Our Ref: SSD 8859

**Request for Additional Information
Elizabeth Drive Business Hub, Cecil Park (SSD 8859)**

The Department has reviewed the Development Application (DA) and environmental impact statement (EIS) for the Elizabeth Drive Business Hub that was lodged on 14 August 2018, in consultation with Fairfield City Council and relevant agencies.

DEVELOPMENT APPLICATION

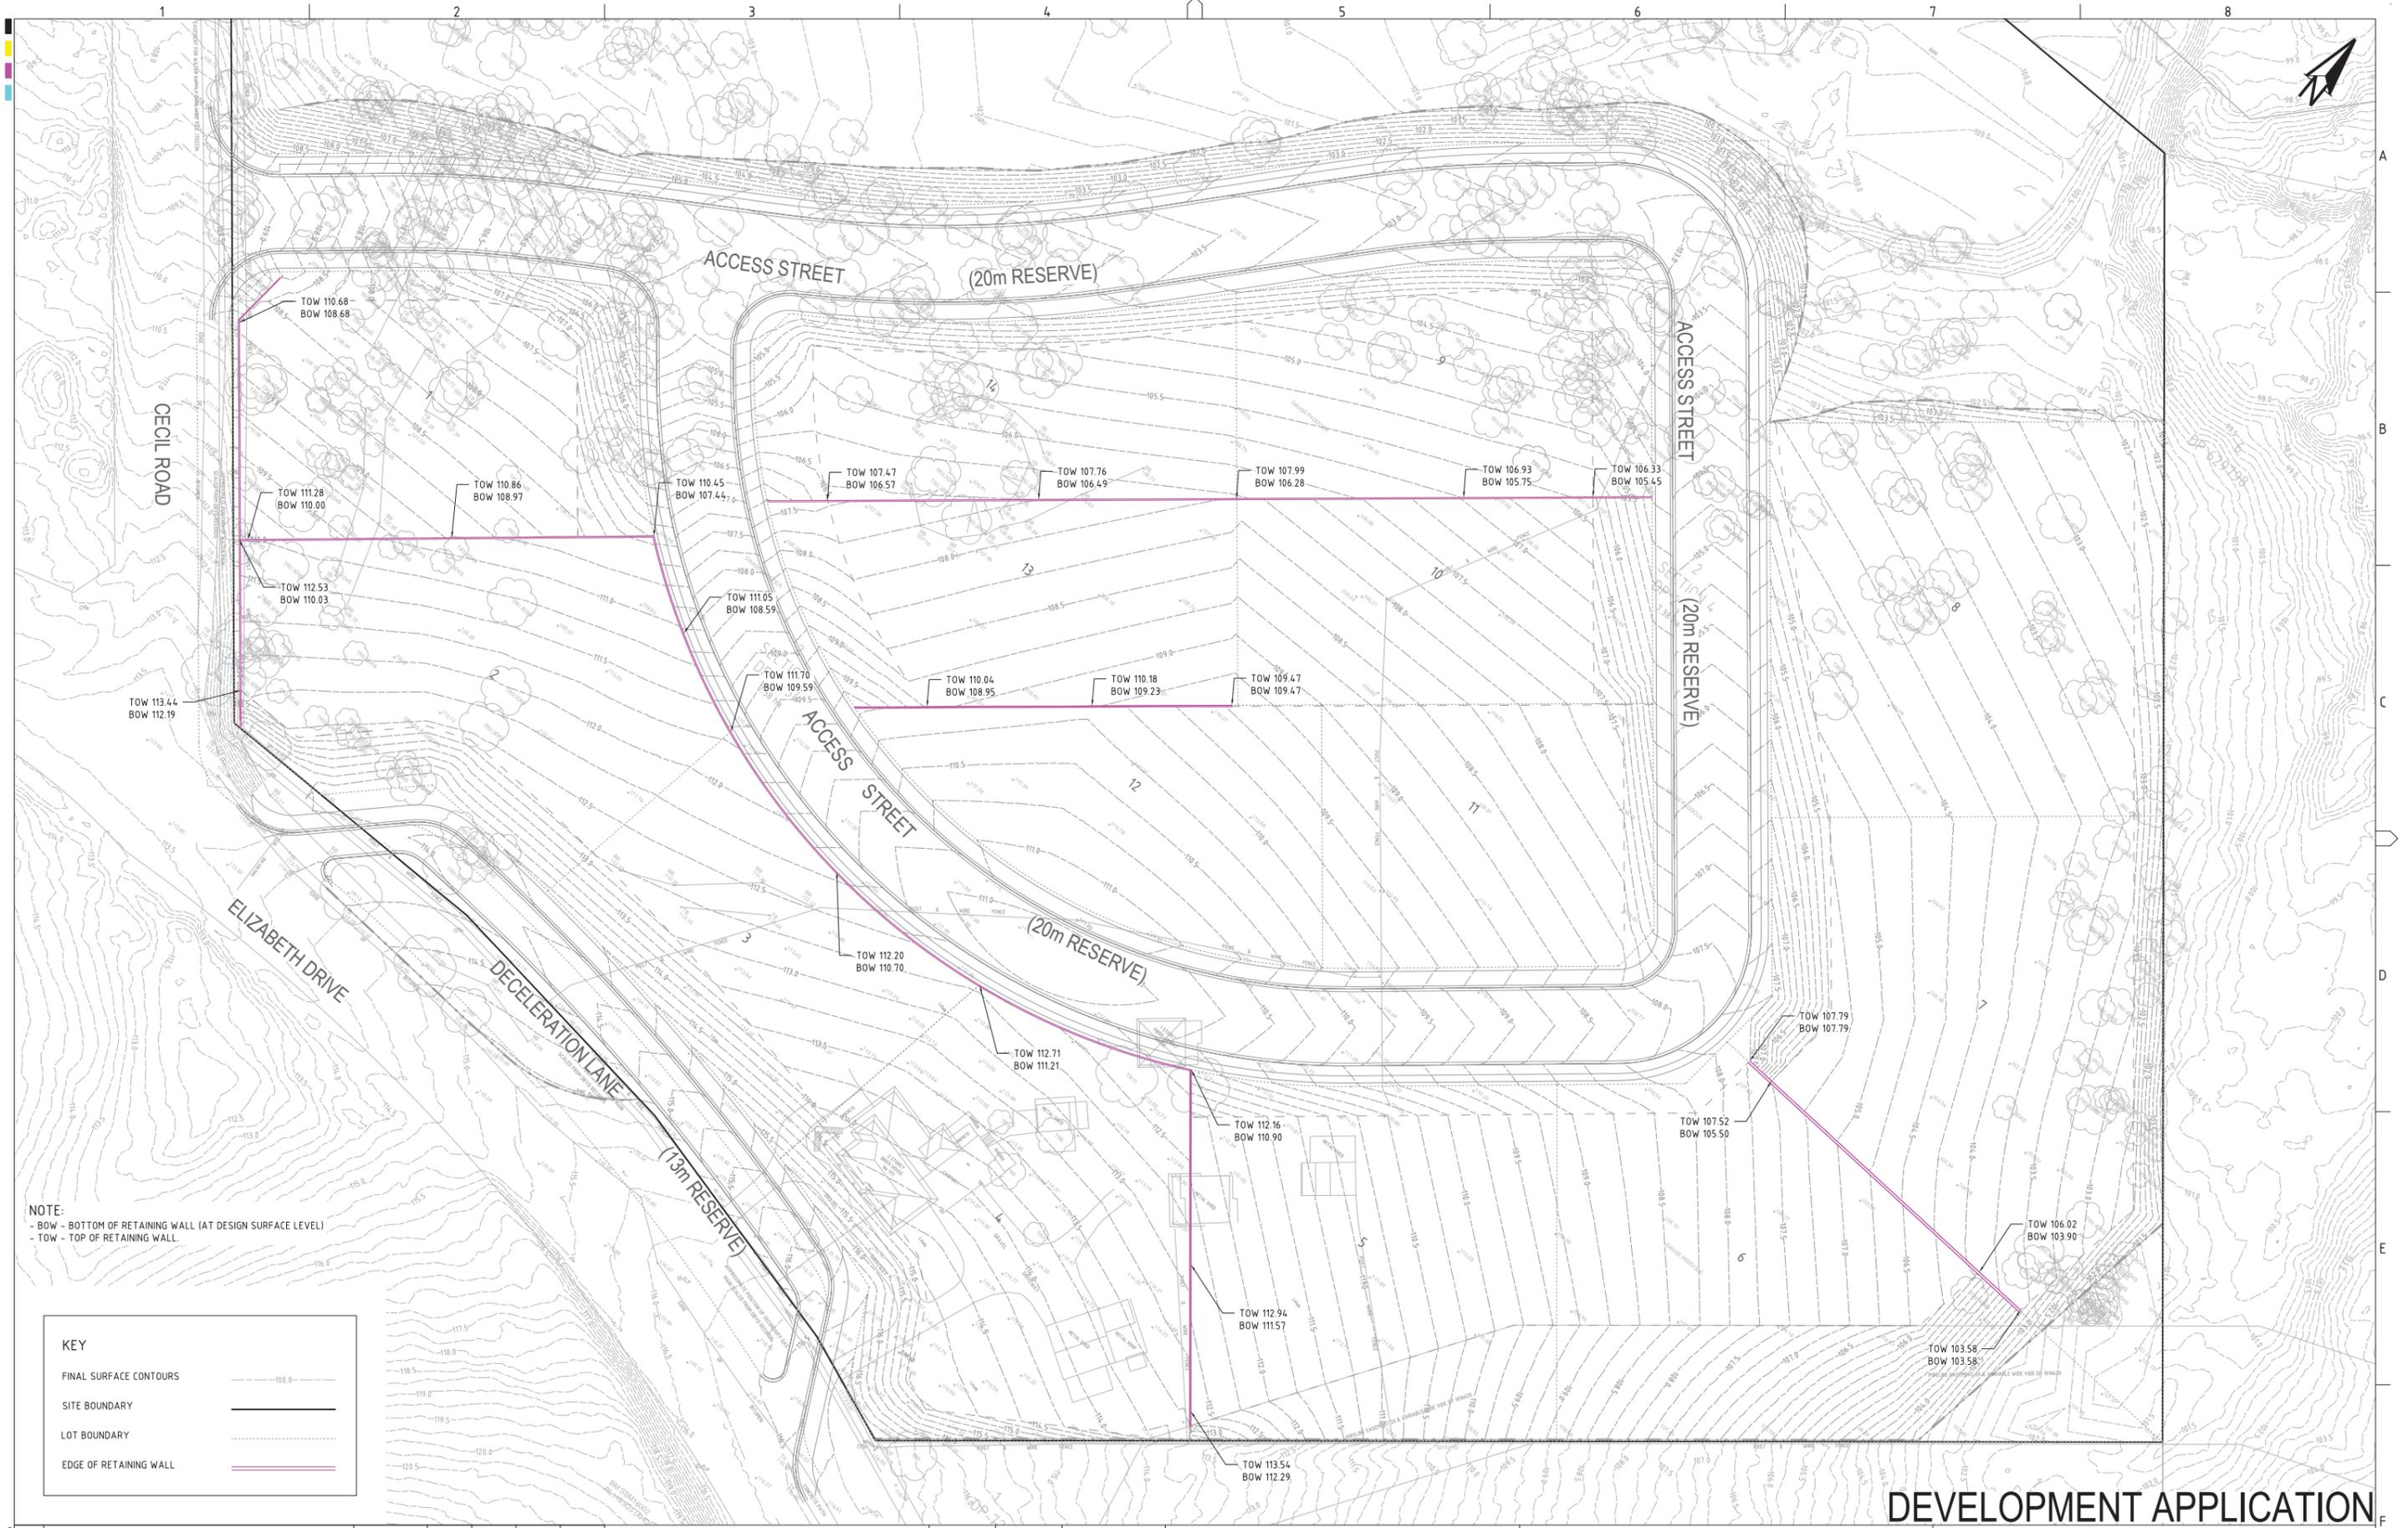
Figure 4 of the EIS identifies the proposed M12 motorway will be located directly to the south of the site. However, there is no discussion of this in the EIS. The EIS must include a description of all proposed developments in the vicinity of the site to understand how the locality may change in the future and any interactions between this proposal and the M12 motorway.
Plans of any proposed works	<p>As outlined in Attachment 1 of the SEARs, the plans must include a locality/context plan which identifies significant local features (including nearby sensitive receivers), the location of existing buildings and any public transport nodes. Please provide a locality/context plan as requested in the SEARs.</p> <p>Refer to comments on Stormwater Management Plan below.</p> <p>The 'Earthworks Grading Plan', the 'Earthworks Cut-Fill Plan', 'Pavement Plan' and 'Retaining Wall Plan' are in draft form. Provide final copies of these plans.</p>
